From: Laura Gibbons
Sent: 04 February 2019 14:18
To: Planning.Responses
Cc: Anita Gardner
Subject: RE: Planning Consultation on: F/30/18/PL

APPLICATION F/30/18/PL

Site Address: Wicks Farm Ford Lane Ford BN18 0DF

Description of Works: 3 No. multispan polytunnels

Title
CONSTRUCTION DETAILS

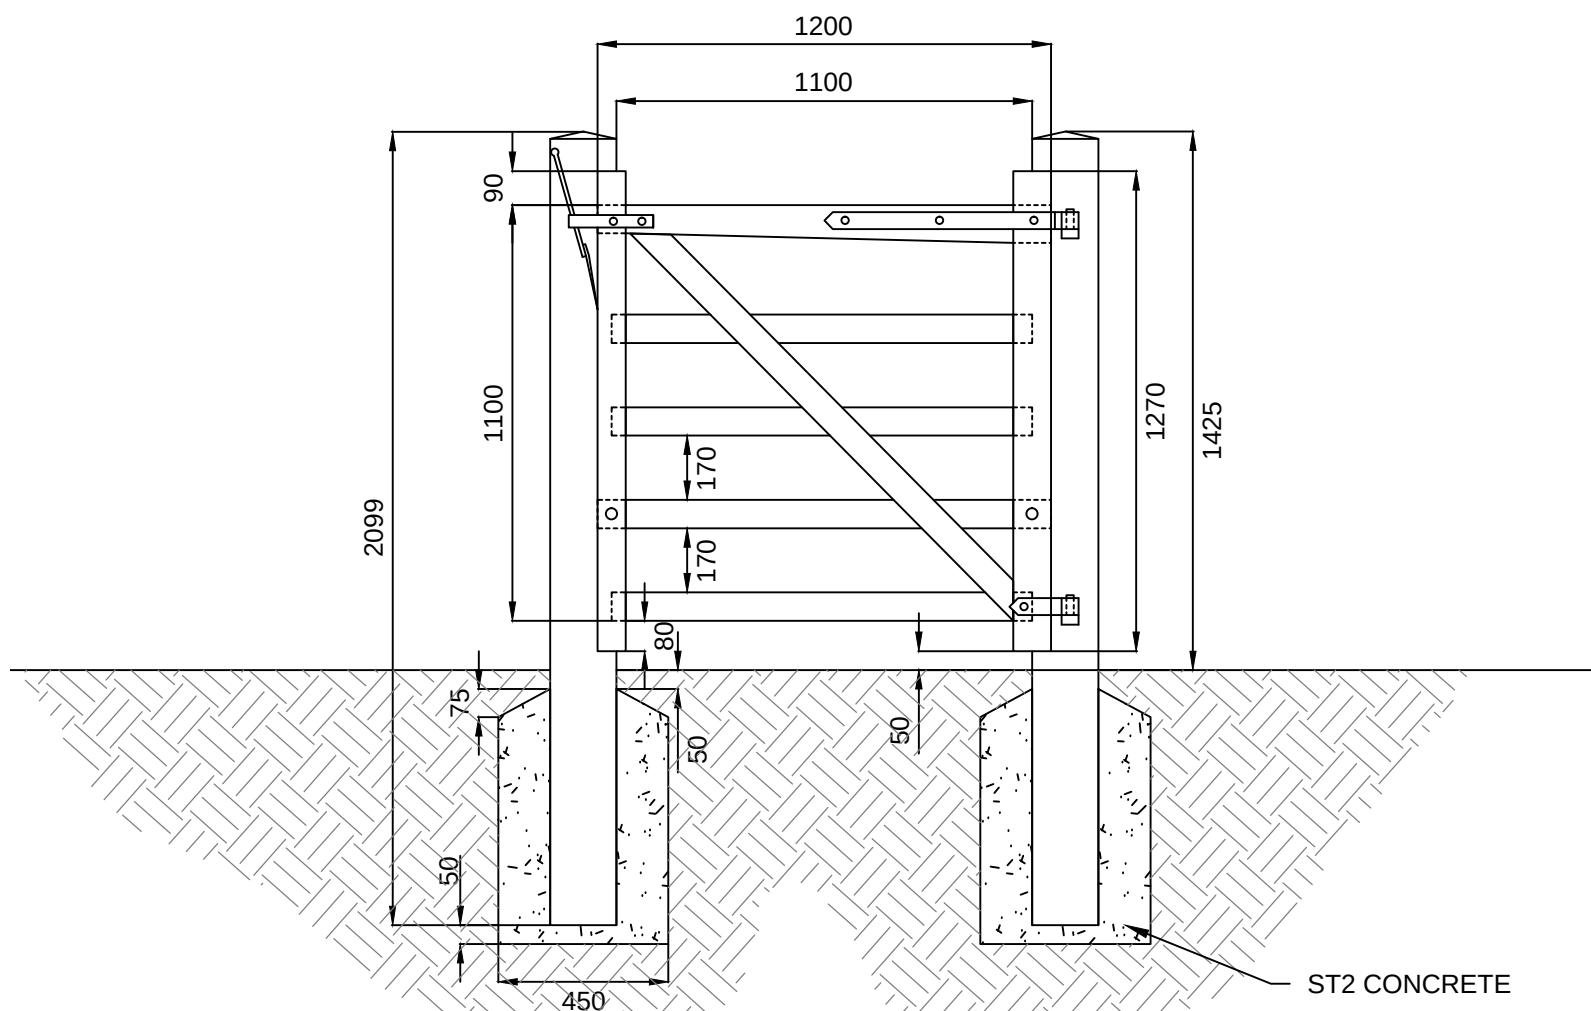
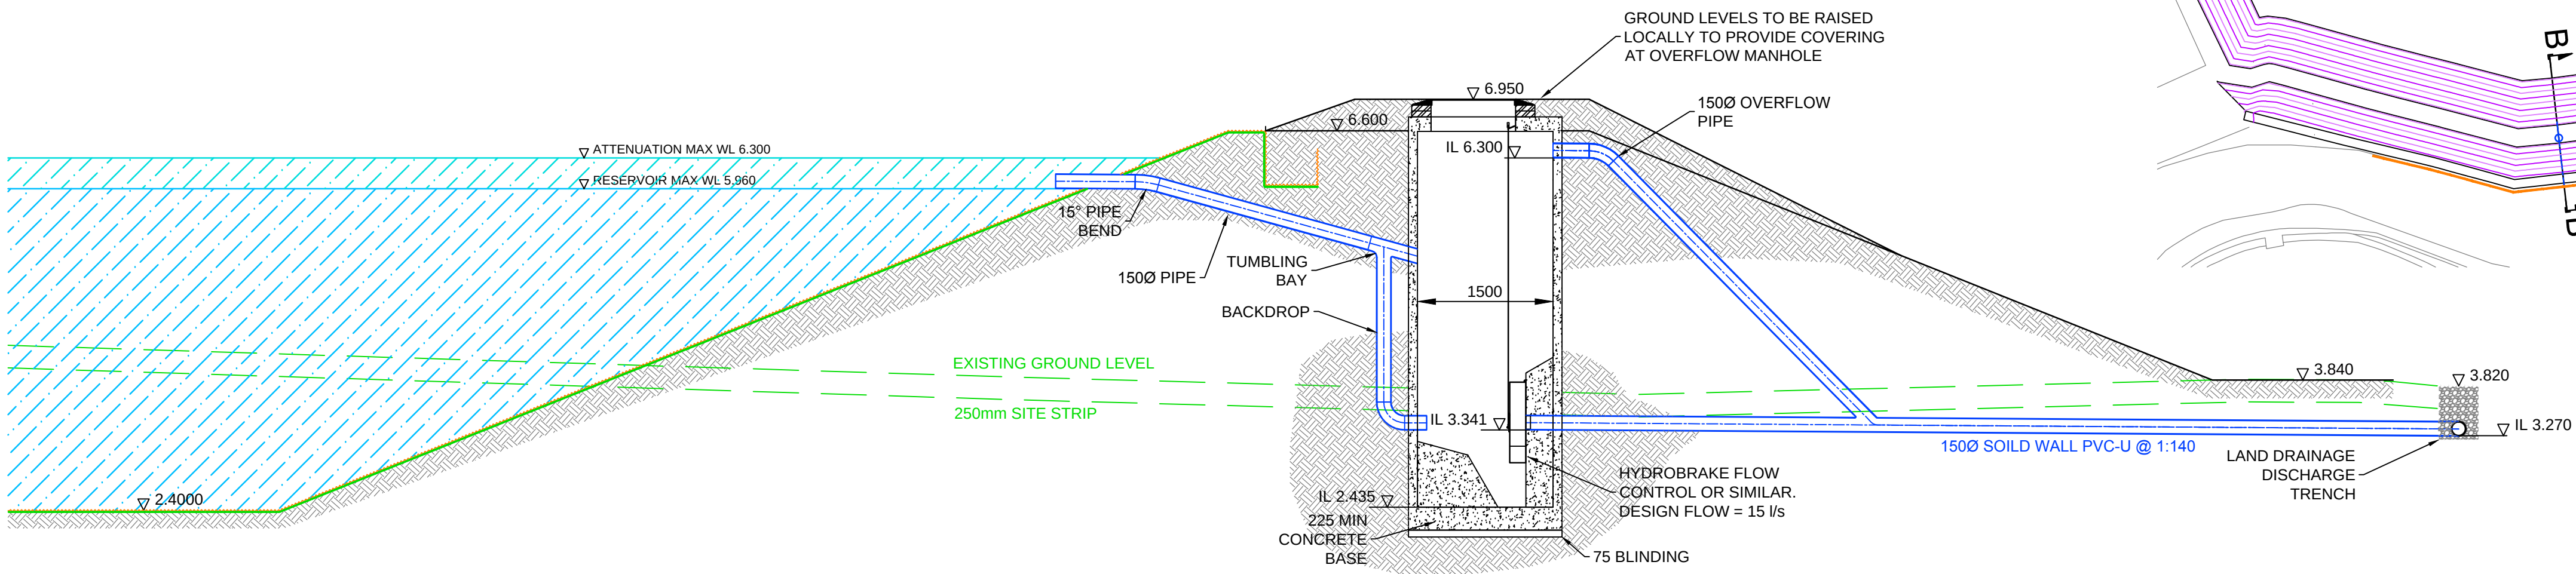
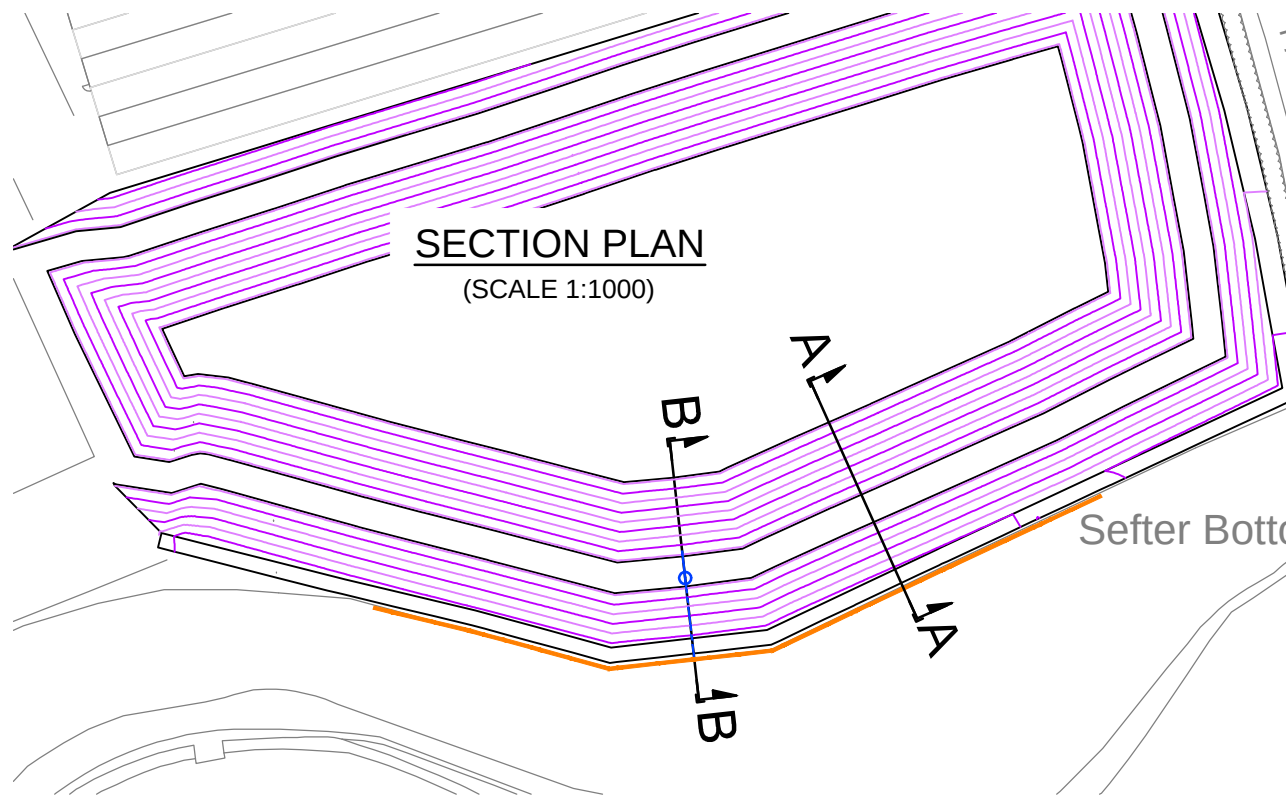
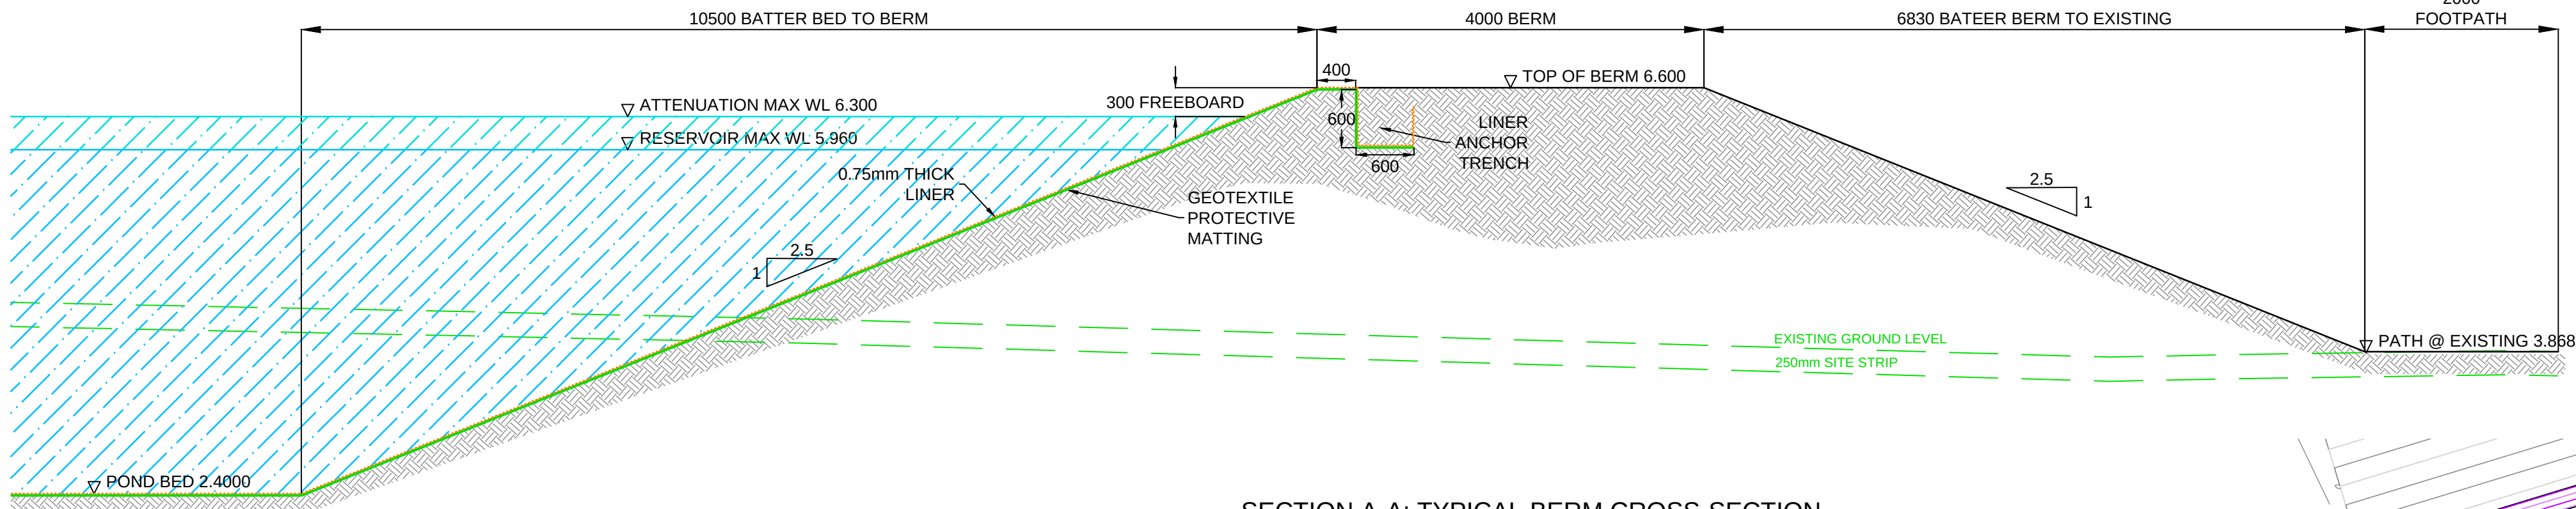
The proposed development includes a 4m deep lagoon. It is unclear where surface water will be discharged when less irrigation is required, i.e. in winter months. No calculations or details have been provided to demonstrate that the proposals will not increase flood risk. The proposals seem to demonstrate that most of the 14,000m³ capacity will be contained below ground, groundwater monitoring is required to demonstrate if the basin needs to be lined or not. Associated flotation calculations and details will need to be submitted if groundwater is found to be higher than the base of the lagoon. The lagoon is proposed close to the railway, therefore network rail should be consulted.

Infiltration must be investigated.
